Memo

TO: Mr. Gerry Kaelin
JOB SITE: Lot at 4825 East Mercer Way
FROM: Scott D. Baker, Registered Consulting Arborist
DATE: 2-28-08
SUBJECT: 2-27-08 site visit to observe Eagle tree and observe air excavation South of tree.

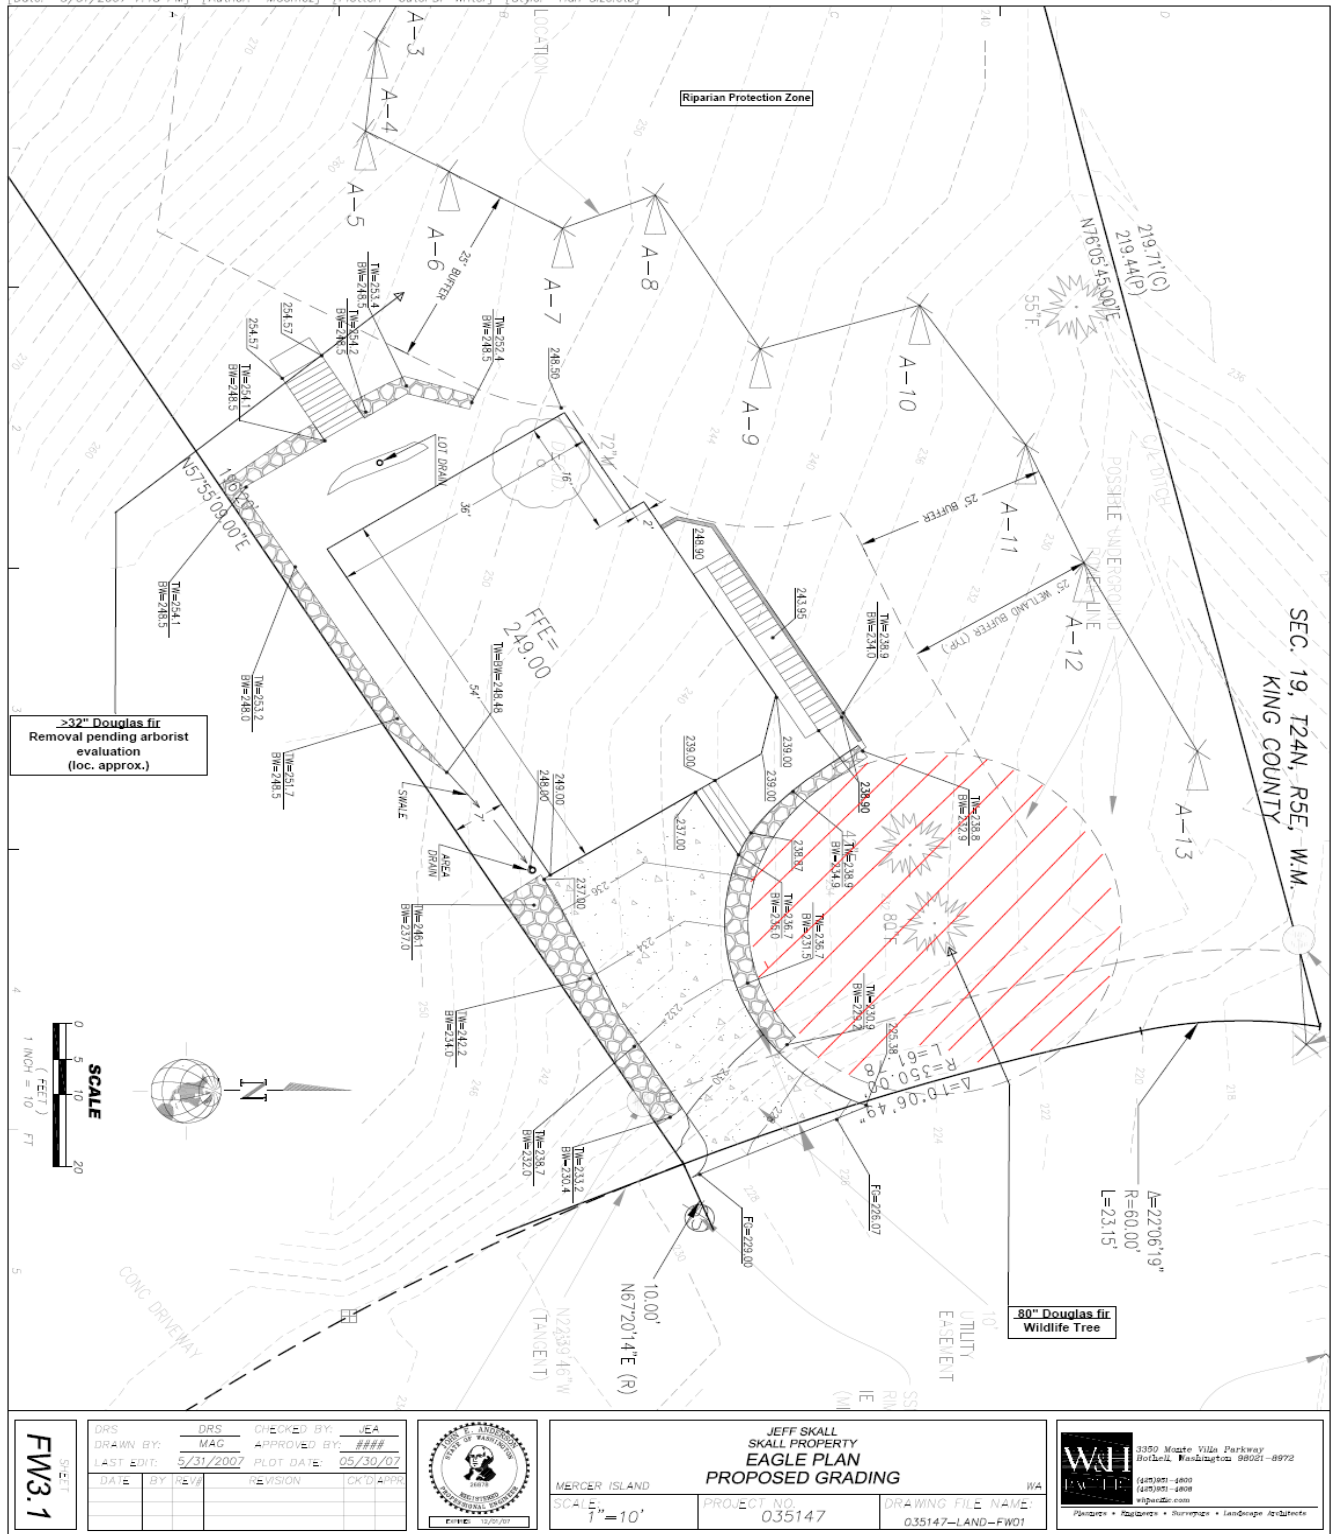
This plan shows a 20' radius circle around the tree as protected with a rock retaining wall around a portion of it. The cut on the South side of the tree needed to build the driveway was shown and this was explained to me by Mr. Skall. The driveway would start out at a steep angle. It would require about a 5' cut at the top of the bank above the road and taper to a shallower cut as the driveway ran West toward the house.

I noted that a significant cut would be made along the South edge of the property and contained by a placed rock retaining wall. This cut and the wall required to contain it would be as tall as 10' at the West end along the proposed house. The cut will sever the soil layers along this line and will likely, along with the other infrastructure impacts to surface soils, significantly change the way water flows through soils on the site.

My observations made on the site reinforced my opinion that the tree preservation plan that is currently proposed is not adequate to protect the eagle tree and its companion. Old trees like this one are very fragile and depend on the surrounding forest in many ways. The excavations, grade changes, and removal of several adjacent forest trees will harm the tree. It is, in my opinion, very important to note that the tree was disturbed about 30 years ago when the road was built and this new disturbance encroaches into the remaining rooting area that the tree depends upon.

As I mentioned in my earlier letter the 20' circle is far short of the 1'-1.5' protected area per inch of trunk diameter recommended by Matheny and Clark in the book "Trees and Development".

The excavation for the driveway will sever at least three important roots. These roots and any others that may be present but were not exposed in the air excavation may be critical to the stability of the tree. The best information available indicates that the roots within 5 times the diameter of the tree are very critical to stability. As the tree is 6' in diameter I think that it is not advisable to cut any roots 2" diameter or greater within 30' of the tree base. In my opinion, given the great height of the tree, cutting any roots even at this distance would potentially risky.

If the storm water structure is installed in the driveway the additional ditch will extend below the cuts needed for the driveway and more large roots from the fir trees may be encountered.
